**Our ref:** Q210286  
**Your ref:** PP-12881439  
**Email:** johnathan.welton@quod.com  
**Date:** 12 March 2024

### **Axis J9, Phase 3 – Non-Material Amendment**

On behalf of Albion Land (“the Applicant”), please find enclosed an application for a Non-Material Amendment (NMA) to planning permission 21/03177/F at Axis J9 (“the Site”). The application seeks to vary the list of approved plans set out in Condition 2 to alter Unit 4’s loading door arrangements to accommodate the operations of the intended occupiers. Amendments are sought to amend the gate details of Units 4 & 5, and amend the colour of paving alongside the access road. Amendments are therefore required to conditions 24, 25 and 26 to reflect the updated Site Finishes Plan.

Drawing No: 20019 - TP - 026 Rev: A

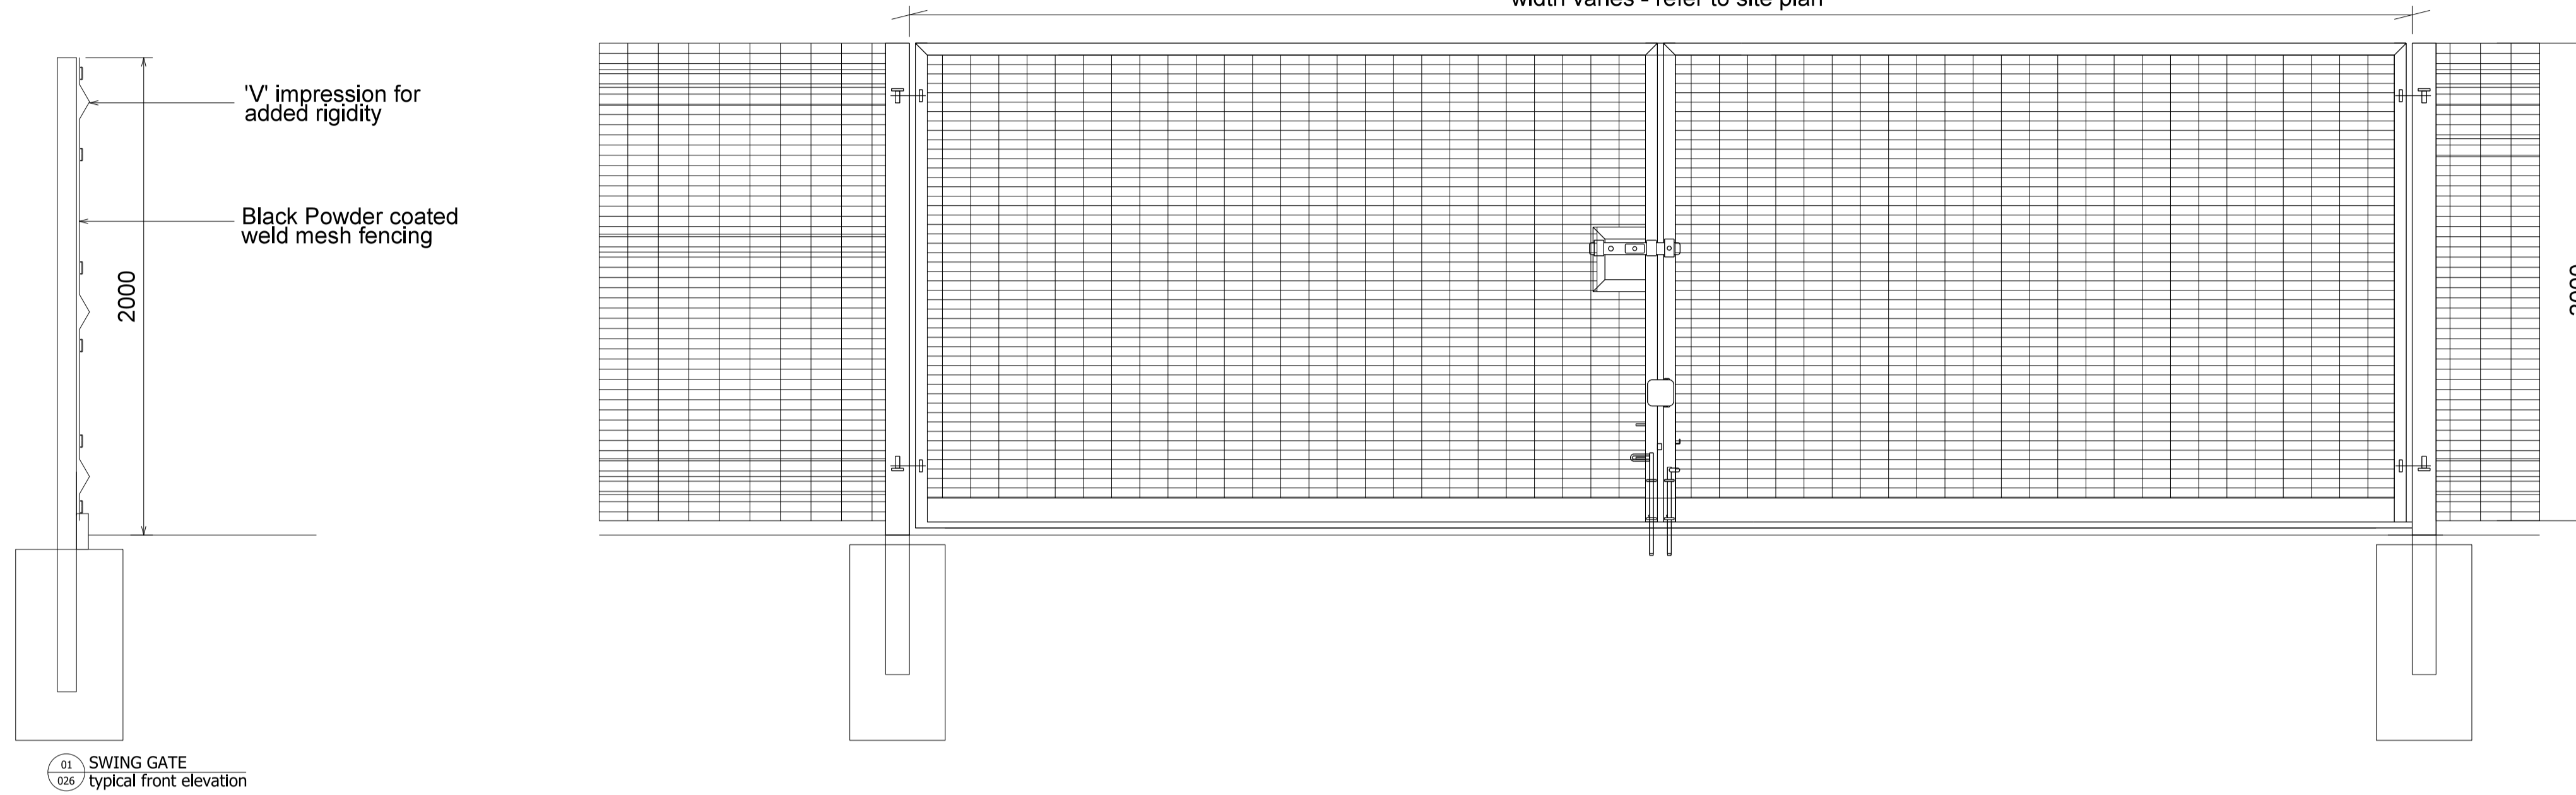
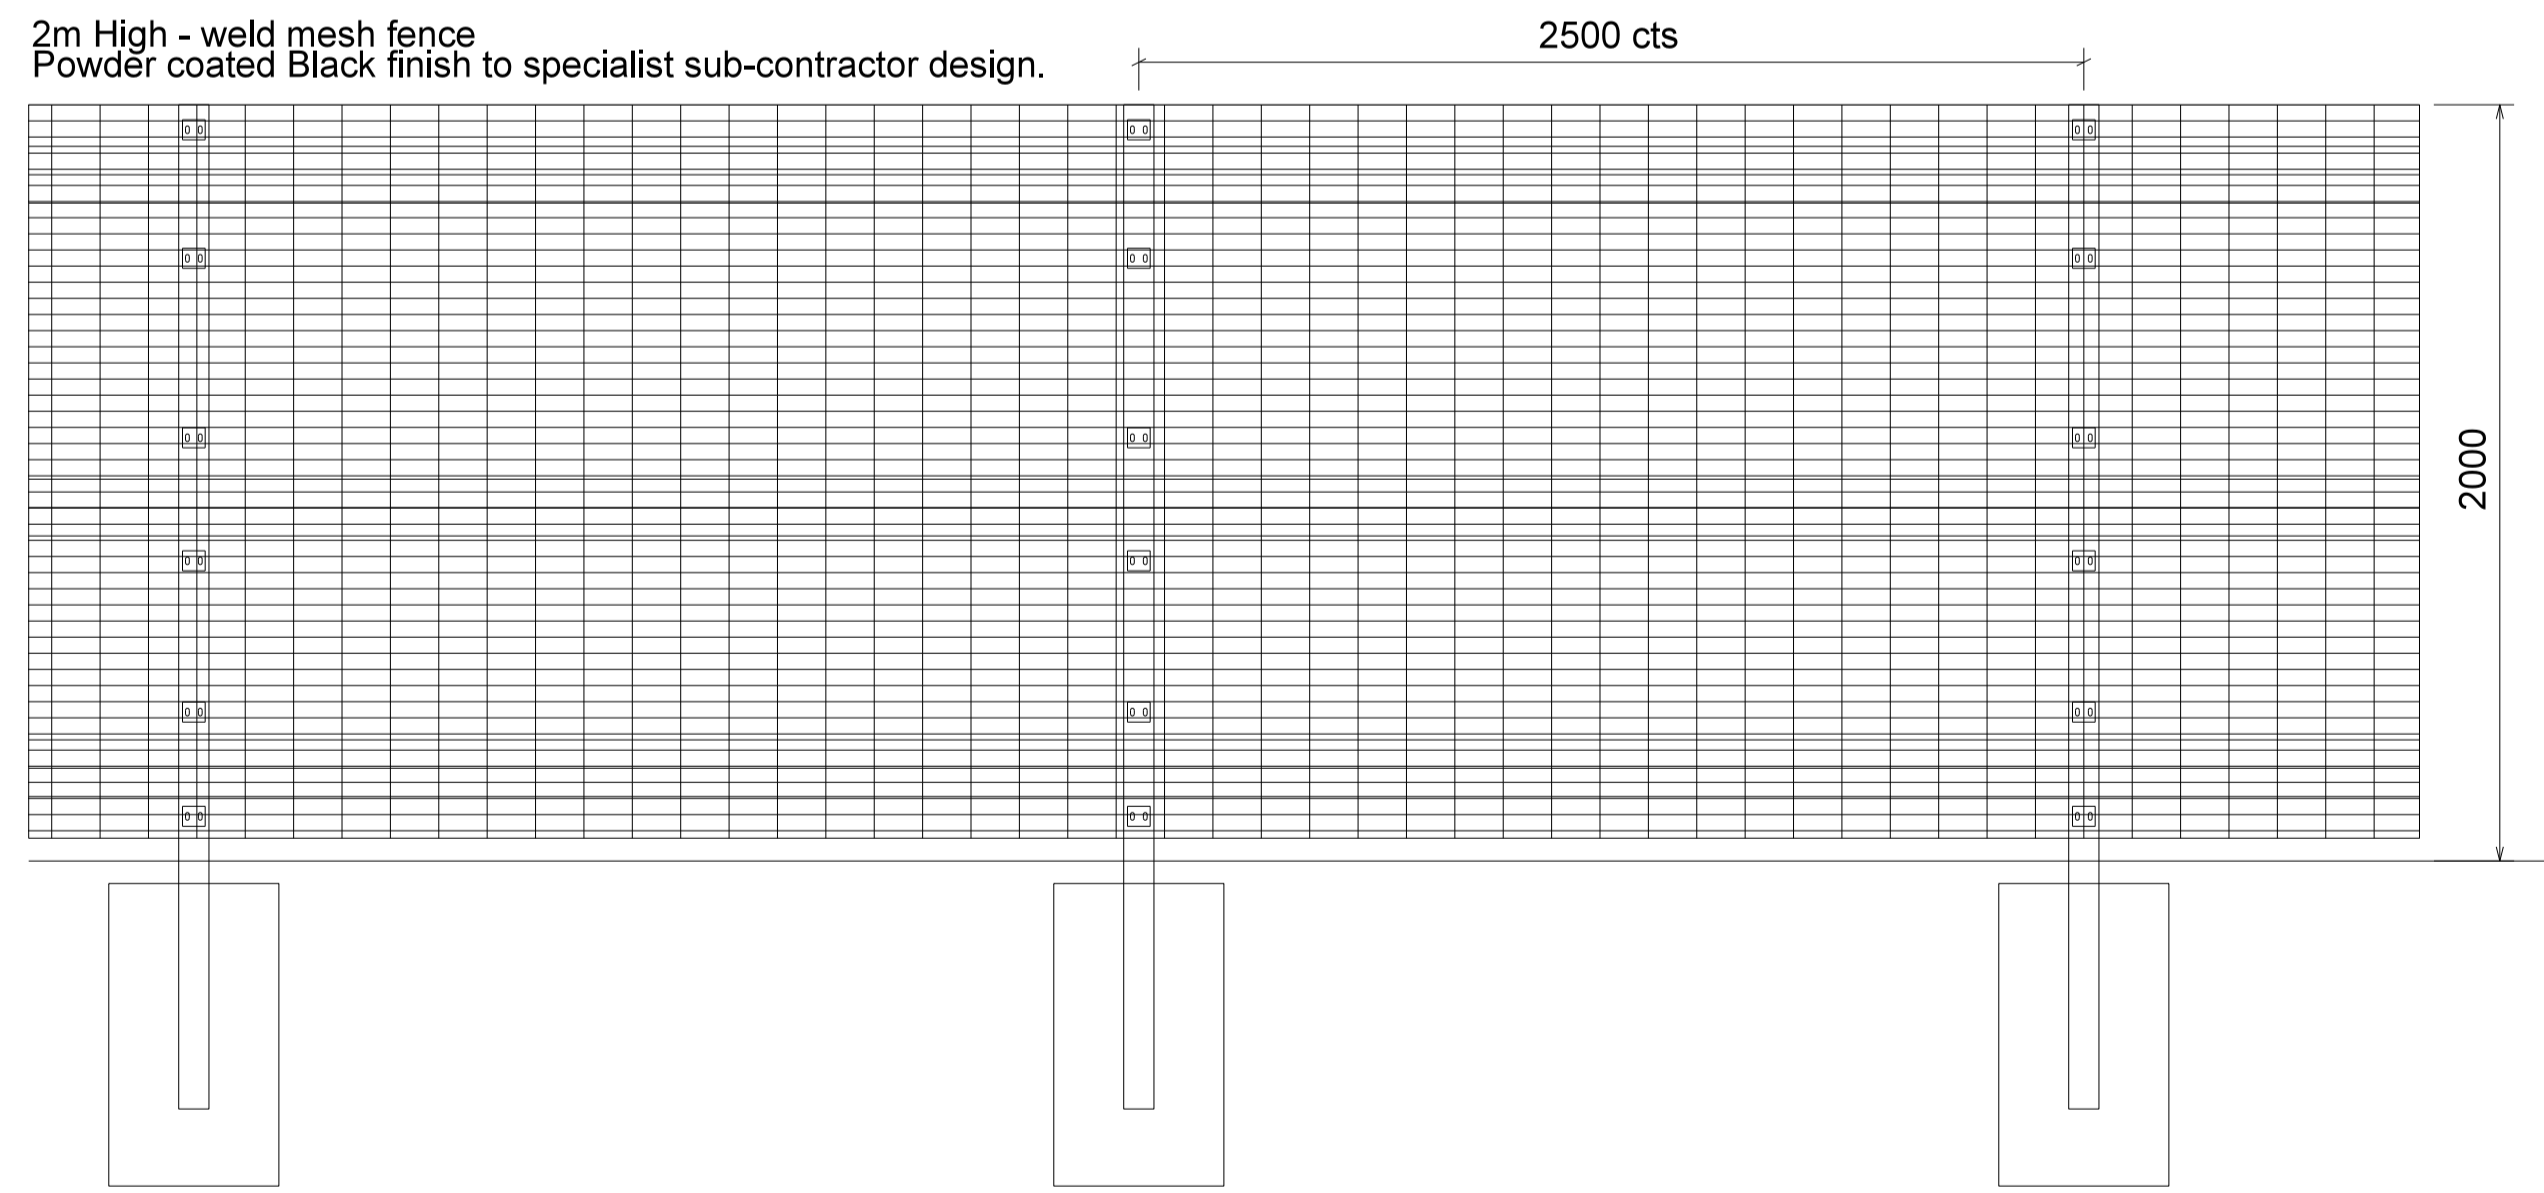
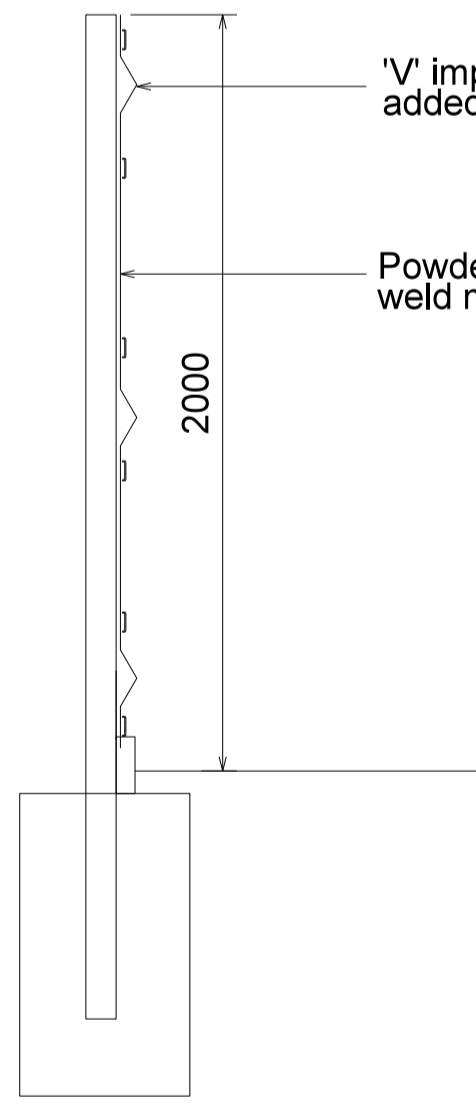
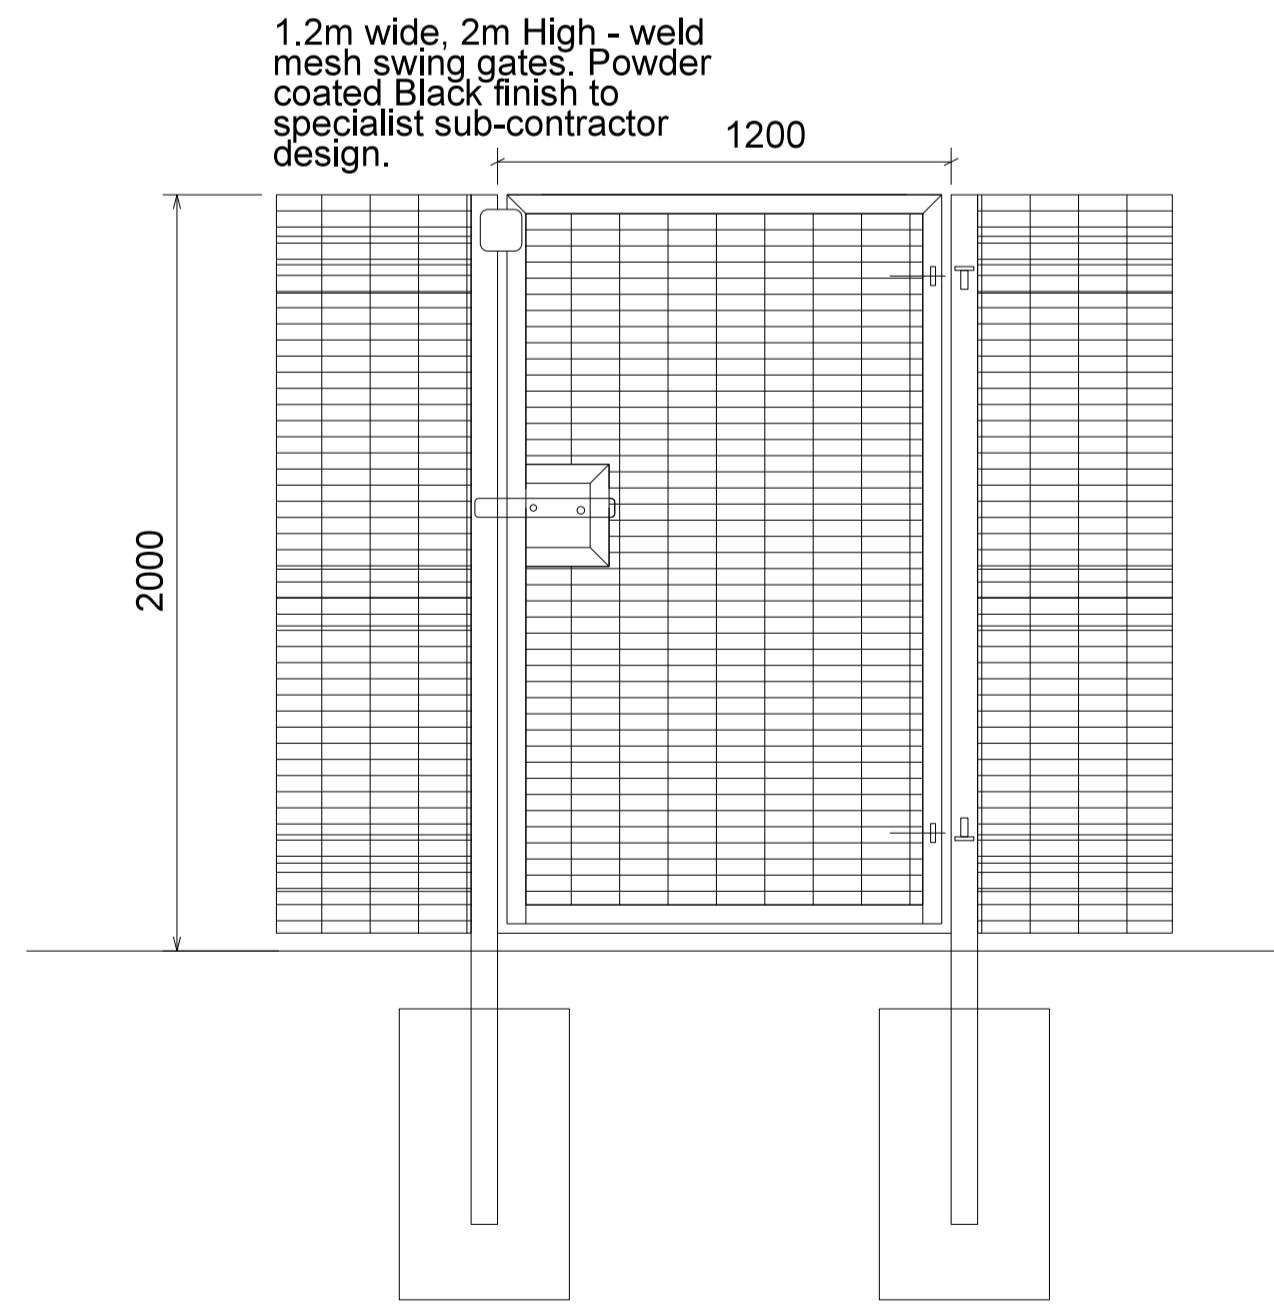
The amendments also seek to amend the gates for units 4 & 5. Table 1 outlines the approved and proposed drawings and summarised changes.

20019-TP-012 Rev E Unit 4 Elevations	20019-TP Rev F Unit 4 Elevations	Updated to show new loading arrangements.
20019-TP-025 Typical Canopy Details	20019-TP-025 Rev A Typical Canopy Details	Updated to remove reference to units 6-11 (which are not part of the approved development) and replaced with Units 1-3.
20019-TP-025 Fencing Details	20019-TP-025 Rev A Fencing Details	Details of entrance to Units 4 & 5 amended to swinging gates.
